EXISTING SITE PLAN
Scale 1:500 @A1

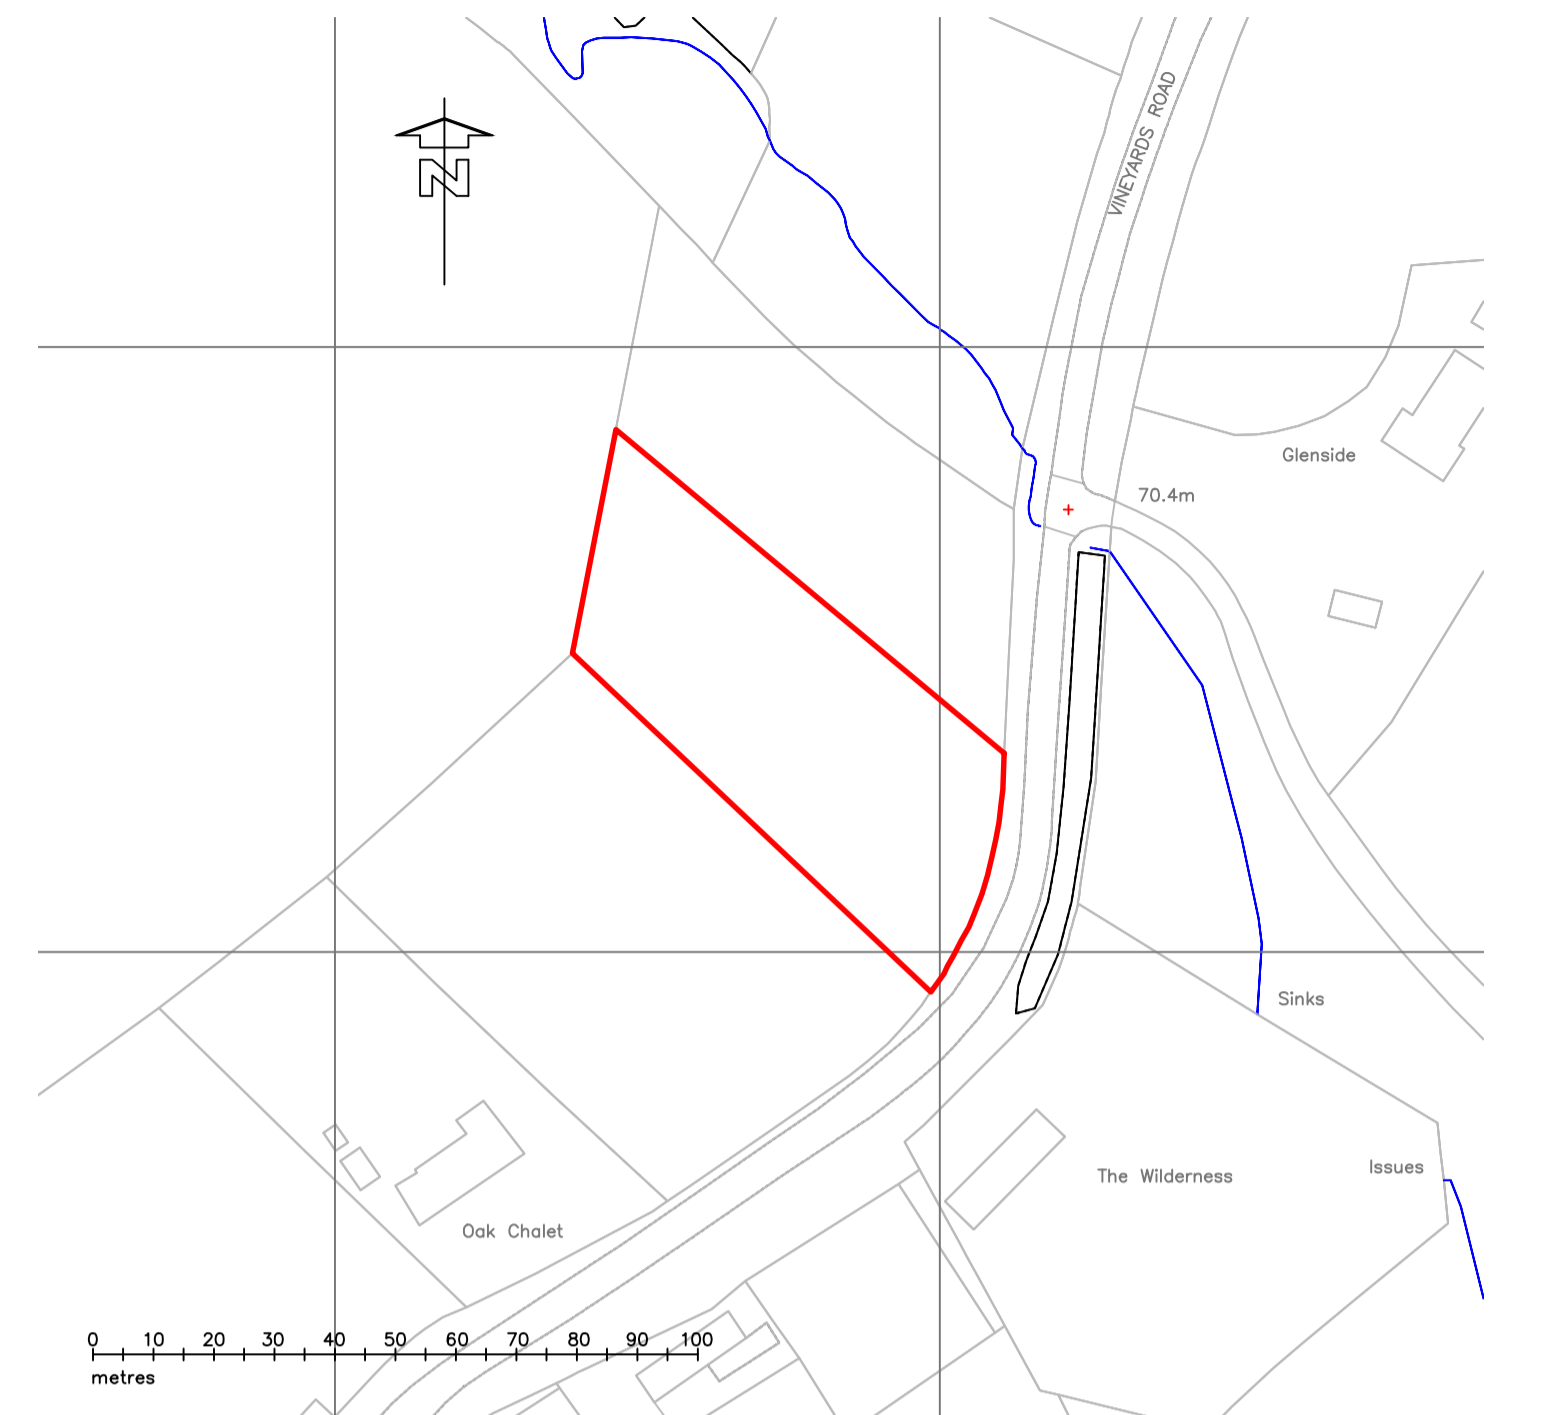
The application drawings are misleading. The “existing site plan” document appears to show a break in the roadside trees / bushes. This “entrance” is only there as a result of unapproved activity which is currently subject to an enforcement action ENF/2022/0122. The picture below from Google Streetview shows the previous unbroken trees and bushes. The document is also misleading in that it labels the area “grass” – it has in fact in large parts been stripped of vegetation and is surrounded by construction fencing.

PROPOSED SITE PLAN
 Scale 1:500 @A1

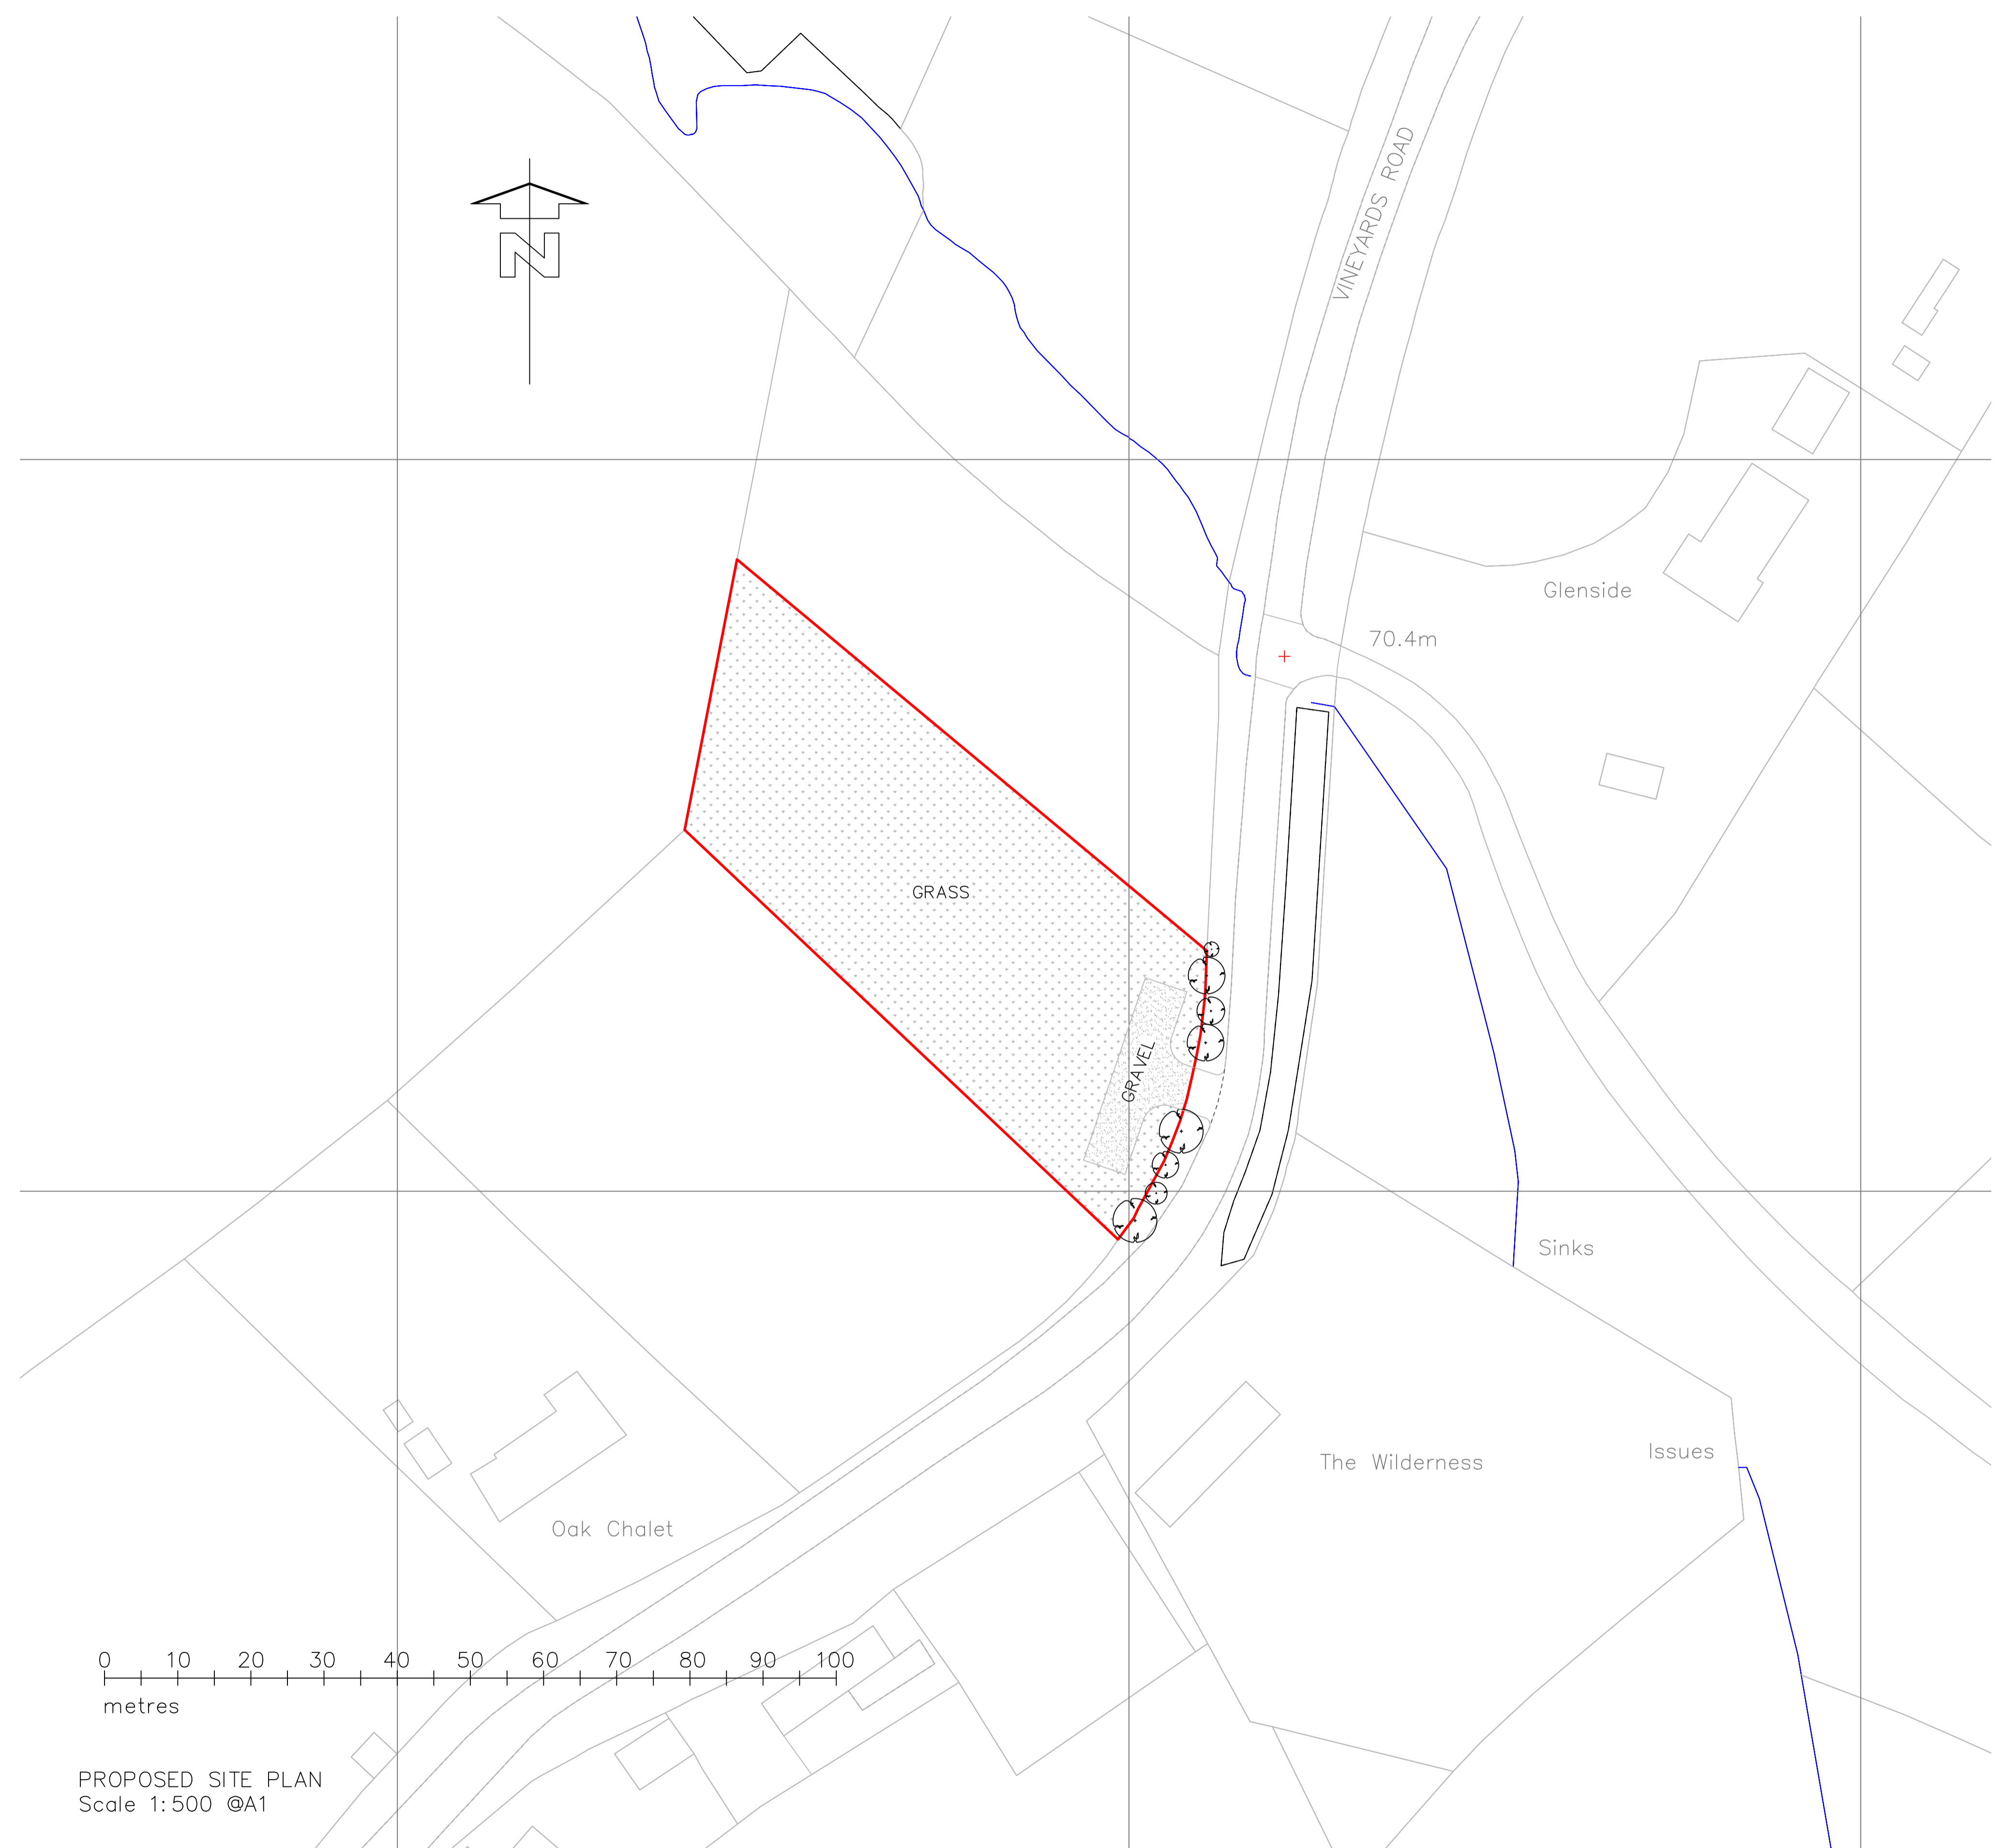
This parcel of grazing / agricultural land was sub-divided last year and auctioned – one of the “plots” has a historic farm gate access. The “plot” in question here does not have that. There is no justification for creating a new entrance here or road / hardstanding on the land itself.

This “plot” is on a very dangerous part of Vineyards Road – it is on the inside of a blind corner that has a large camber to it. Any entrance from land here onto this road would be putting the safety of drivers at high risk. There is no footpath, no lighting and the verge that has already been damaged significantly is owned by a 3<sup>rd</sup> party (the Highways Agency).
